66 St Thomas Drive
Pagham
Bognor Regis
West Sussex
PO21 4UA

13th June 2011

Planning Application P/37/11 - 64 St Thomas Drive, Pagham

Title : Proposed South & East Elevations
Address : 64 St Thomas Drive, Pagham.
Date : 05,04,11
Scale : 1:100
Dng.No : PE06

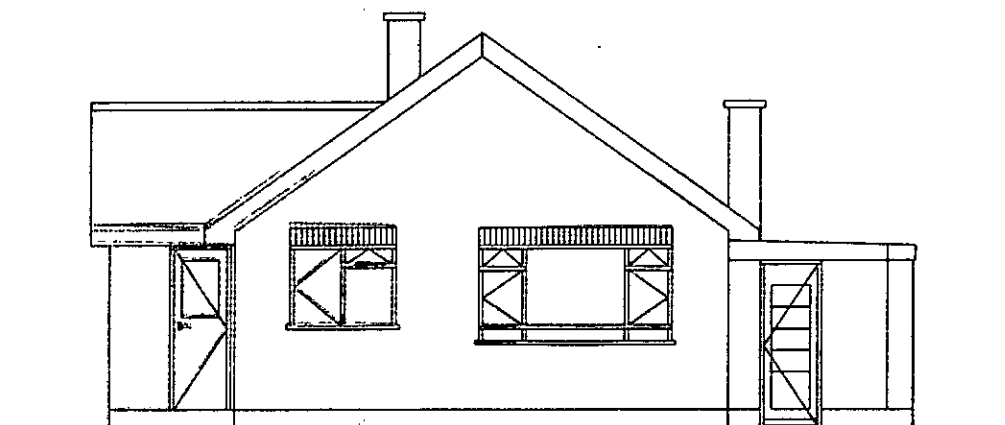
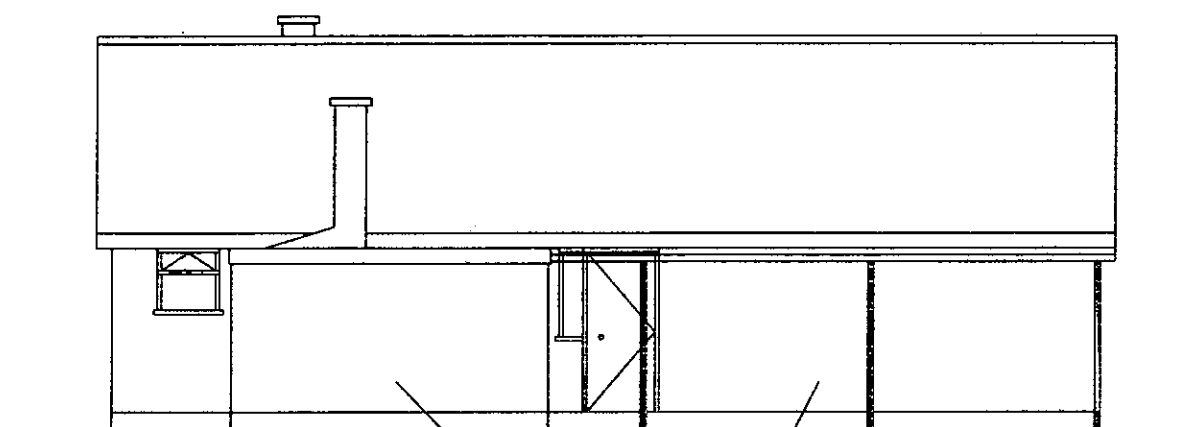
1. The application does not indicate in sufficient detail the construction of the car port, which will be directly adjacent to our Lounge window.
2. The construction of the store, due to its size and position, will significantly and adversely affect the natural lighting into our existing dining area, thereby reducing the amenity of our home.
